CITY OF ALBUQUERQUE

December 13, 2023

**Re: Natural Grocers Retail
4625 Wyoming Blvd NE
Request for Certificate of Occupancy- 30 Day Temp
Transportation Development Final Inspection
Engineer's Stamp dated 2-1-23 (F19D013E)
Certification dated 12-12-23**

BICYCLE RACK

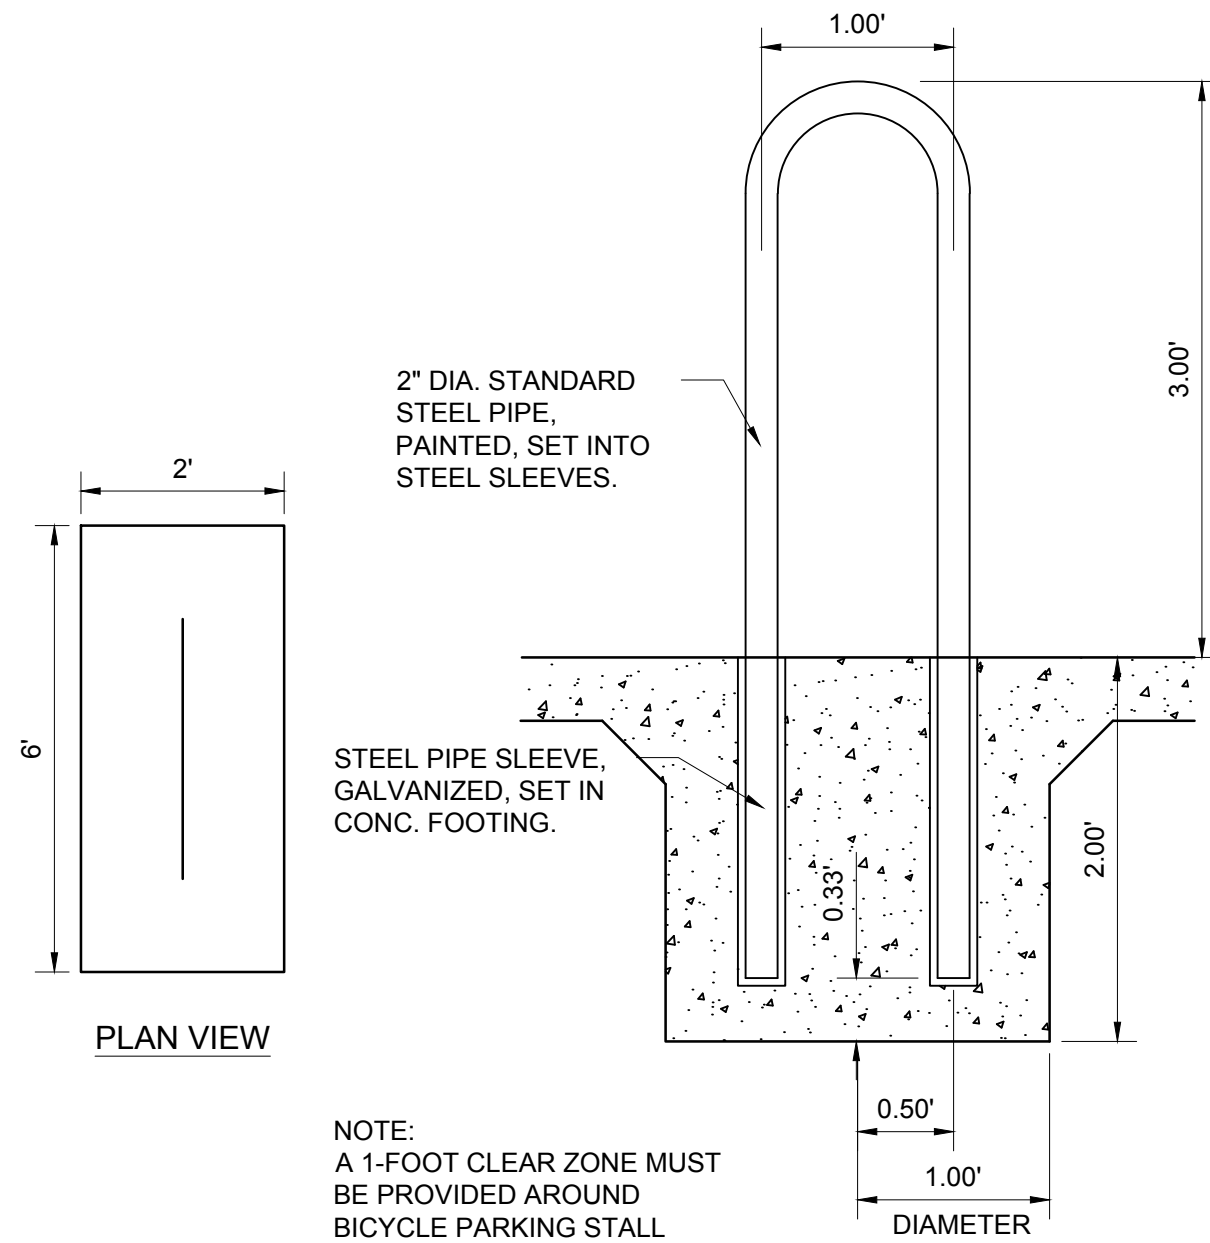
1. The holes in the parking lot where the collars need to be installed, if not filled by COB today, must be barricaded.
2. 7 bicycle spaces are required, the plan specifies 8, but only 4 were constructed. Provide bicycle parking per the approved plan.
3. Complete the sidewalk at the northwest corner of the site.
